A57 Link Roads

**8.3 Statement of Common Ground with
High Peak Borough Council**

8.3 STATEMENT OF COMMON GROUND WITH HIGH PEAK BOROUGH COUNCIL

**Table 3.1: Statement of Common Ground (SoCG) Between National Highways and High Peak Borough Council (HPBC)
 Table of Issues/Matters - Final Version dated 16 May 2022.**

© OpenStreetMap (and) contributors. CC-BY-SA
 Contains OS data © Crown Copyright and database right

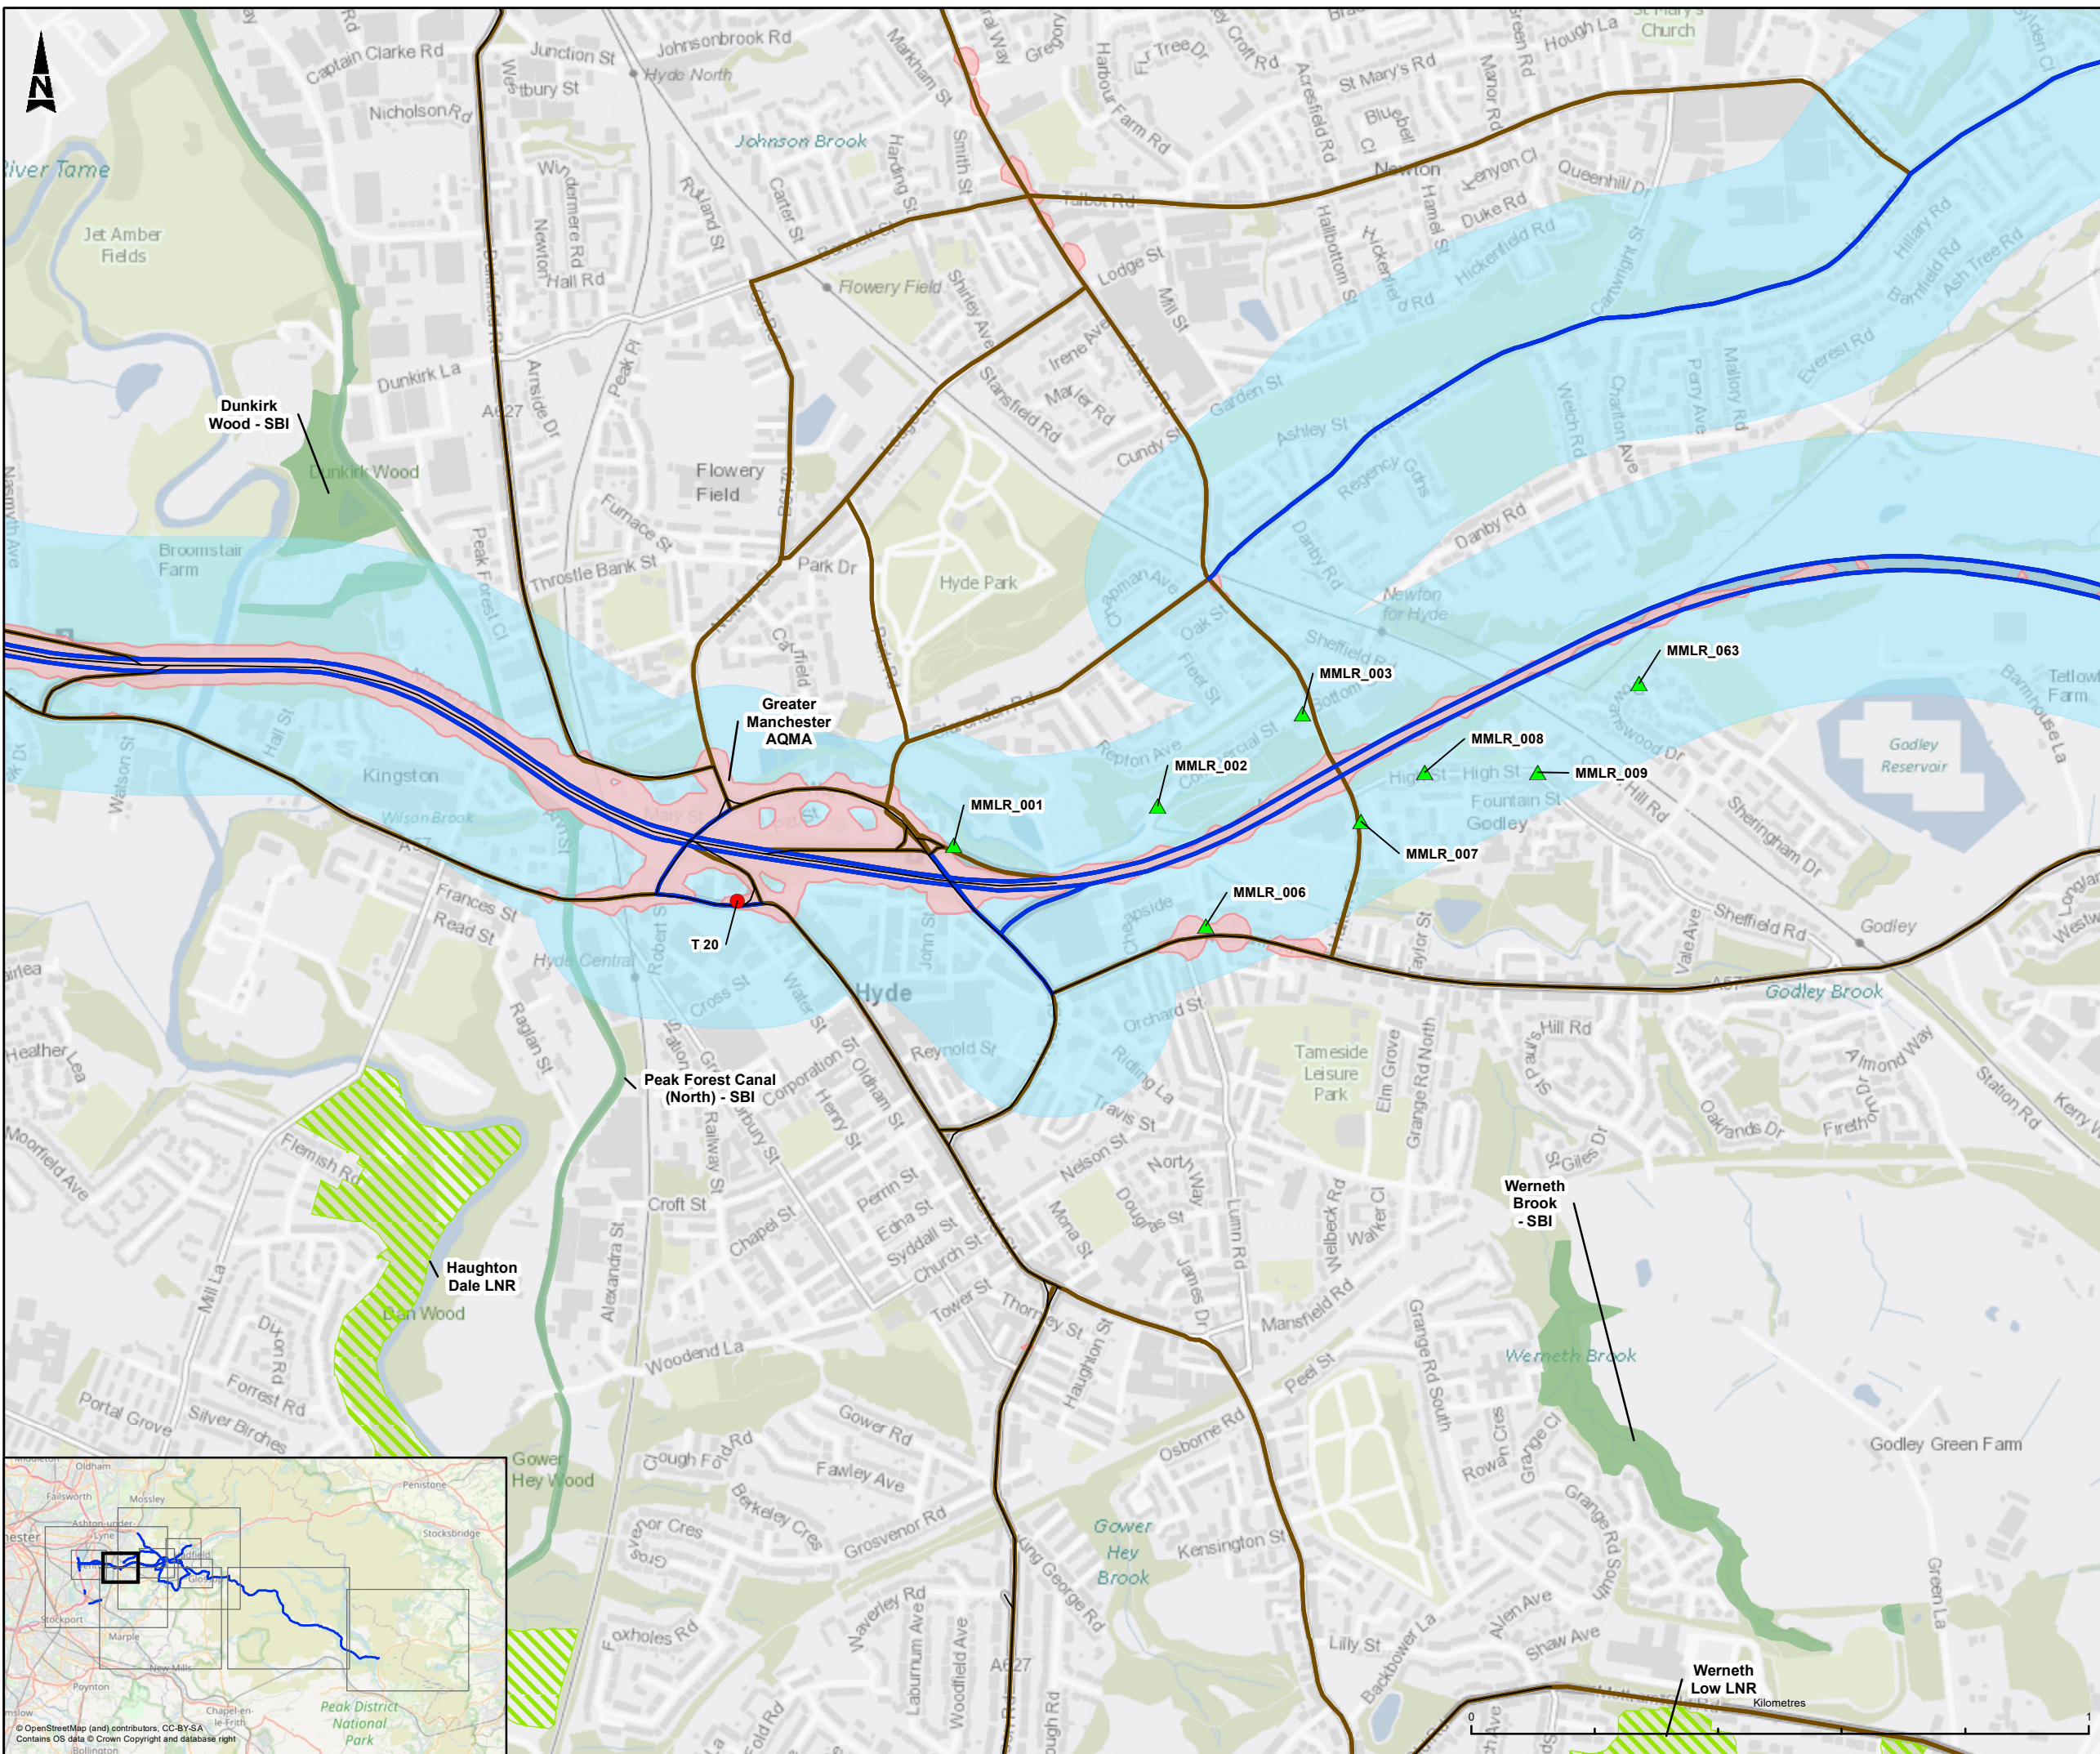
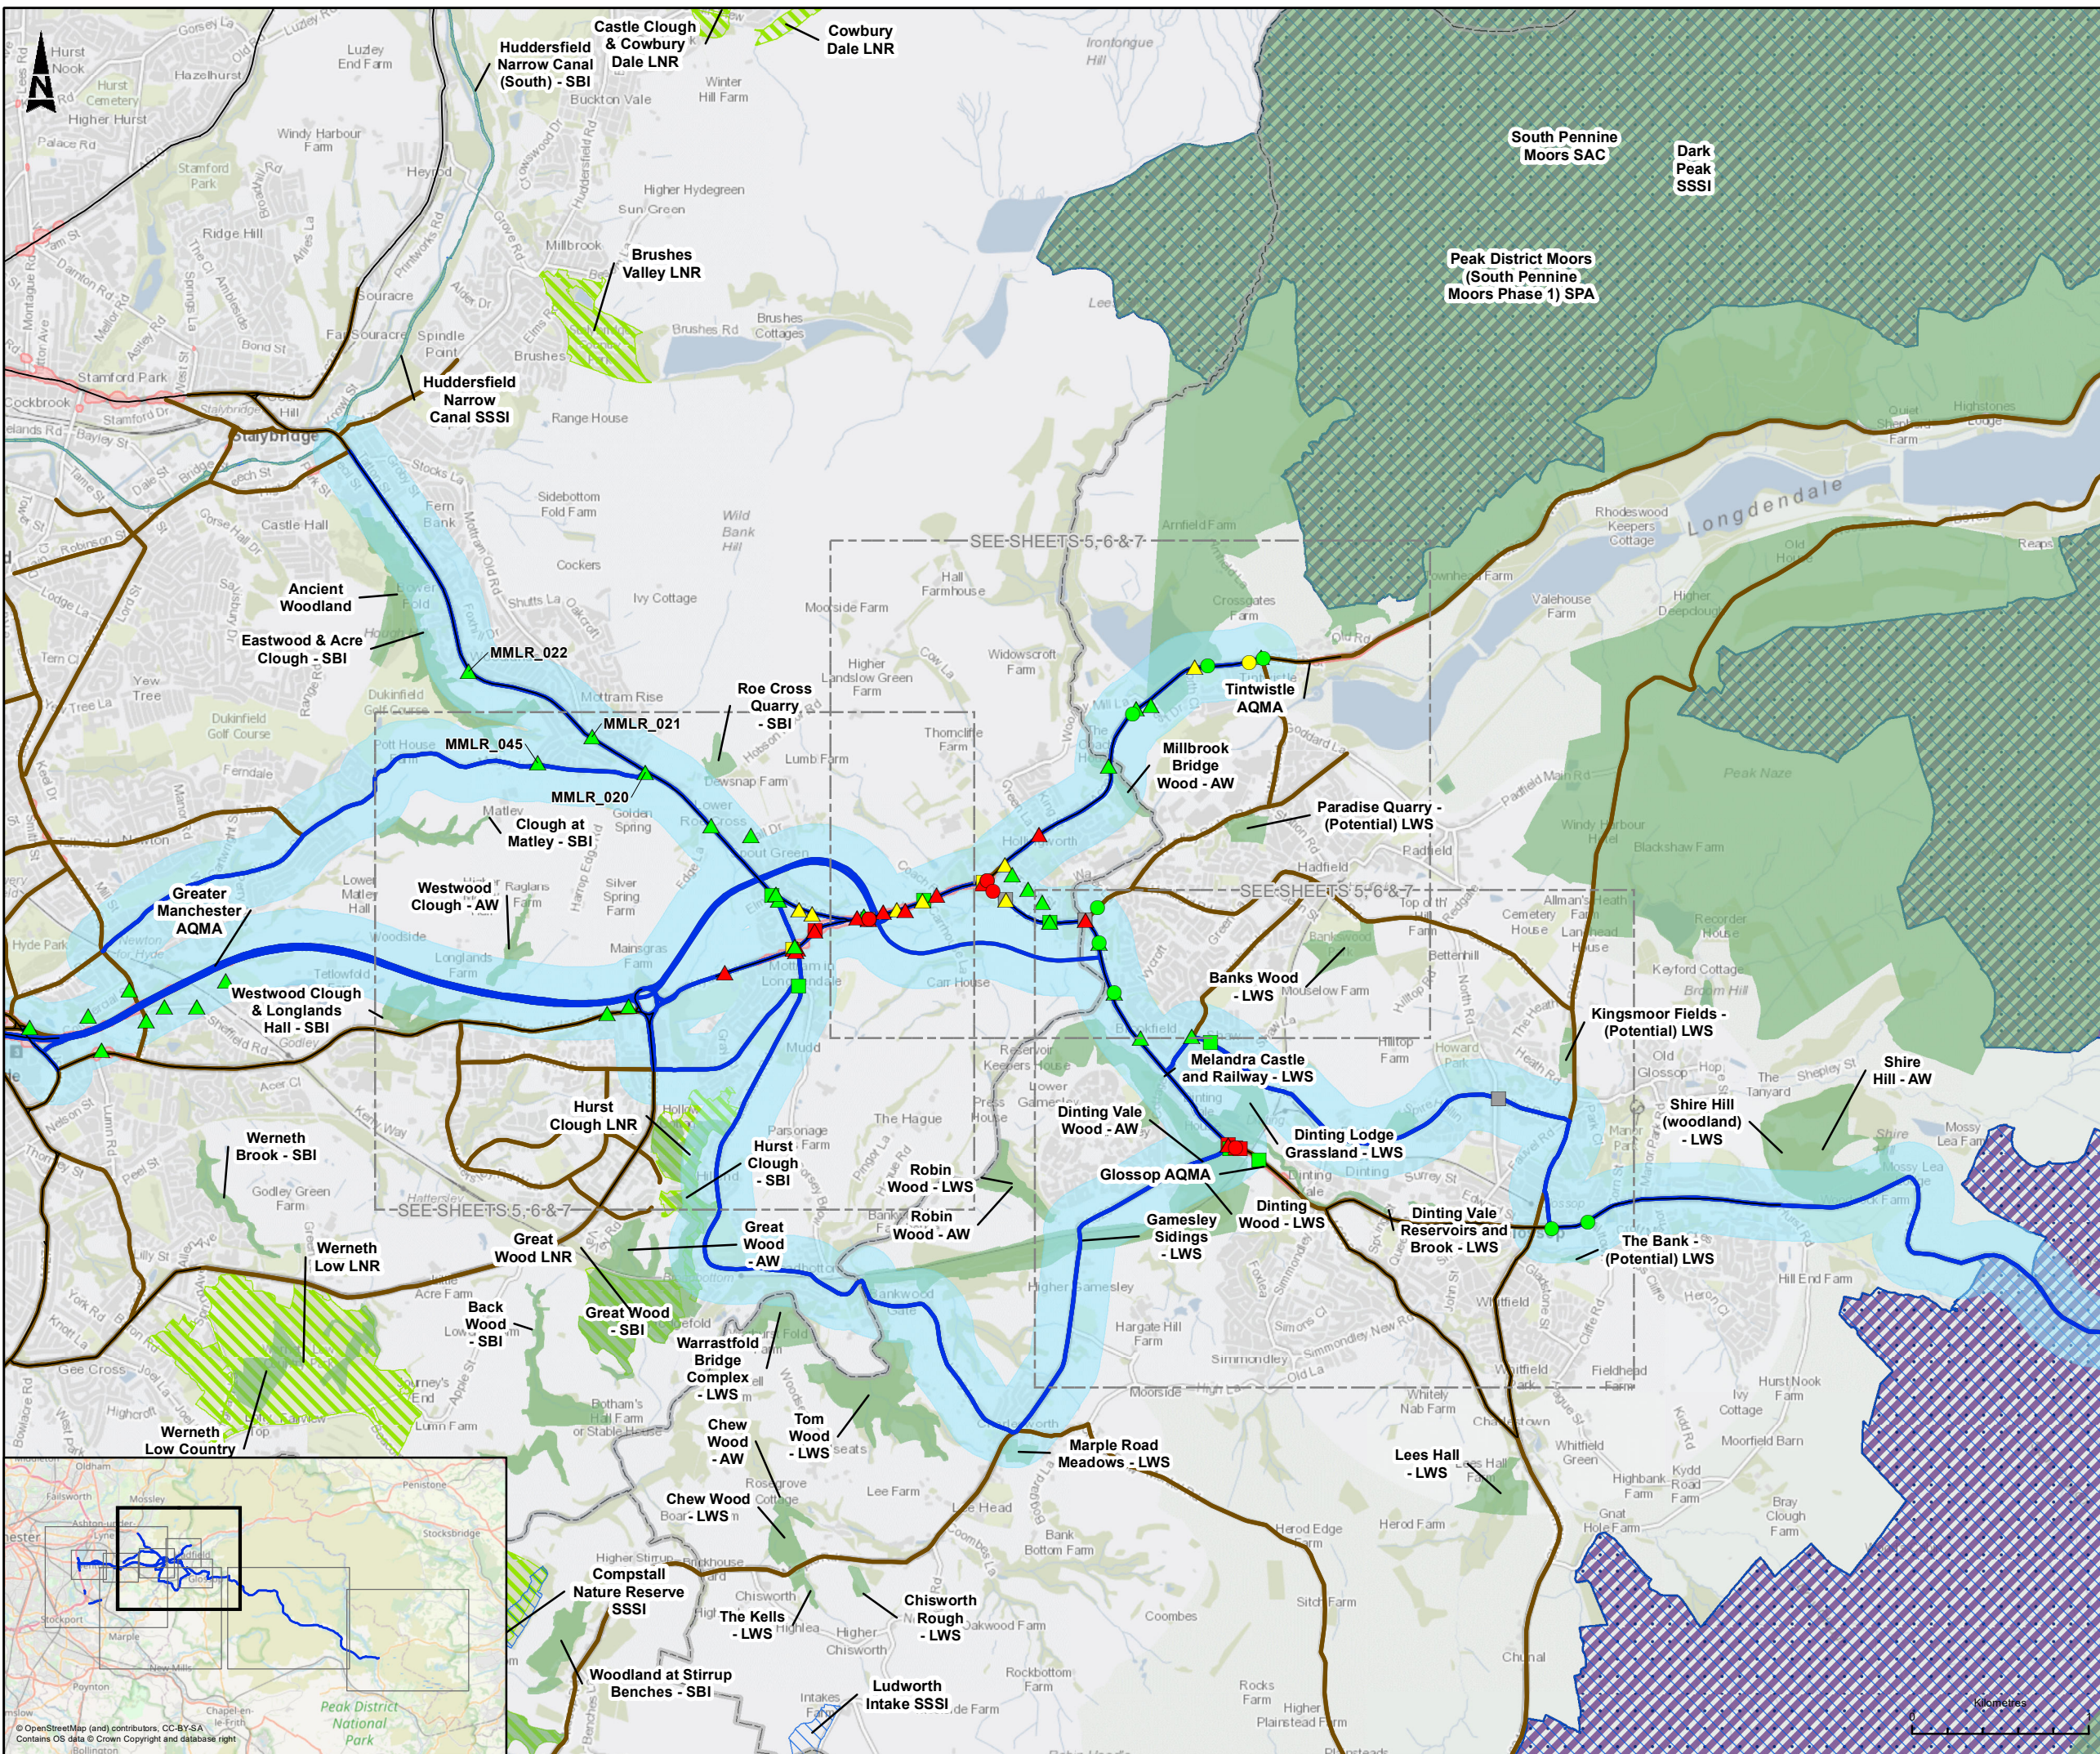
3.1	Environmental Statement (ES) [APP-061]	Air Quality Methodology AQMA's	The Consultee stated that air quality is a major concern. Since the last public consultation on the scheme in 2018, HPBC has designated Air Quality Management Areas (AQMA's) on sections of the A628 in Tintwistle and the A57 at Dinting. Detailed assessment is required.	The Applicant's air quality assessment (in the ES [APP-061]) has taken into consideration the AQMA designated since 2018 in Tintwistle and Dinting Vale. The air quality assessment has been undertaken in accordance with DMRB LA105 with the air quality study area determined on the basis of traffic change criteria given this guidance.	Agreed

3.2	Environmental Statement (ES) [APP-061]	Air Quality Methodology Dinting Vale	The Consultee questioned the air quality results at Dinting Vale.	The air quality assessment has been undertaken in accordance with DMRB LA105 with the air quality study area determined on the basis of traffic change criteria given this guidance. A detailed assessment of air quality has been undertaken for all areas where traffic changes are expected, which includes the Dinting Vale area. Full results will be reported in the Environmental Statement [APP-061].	Agreed
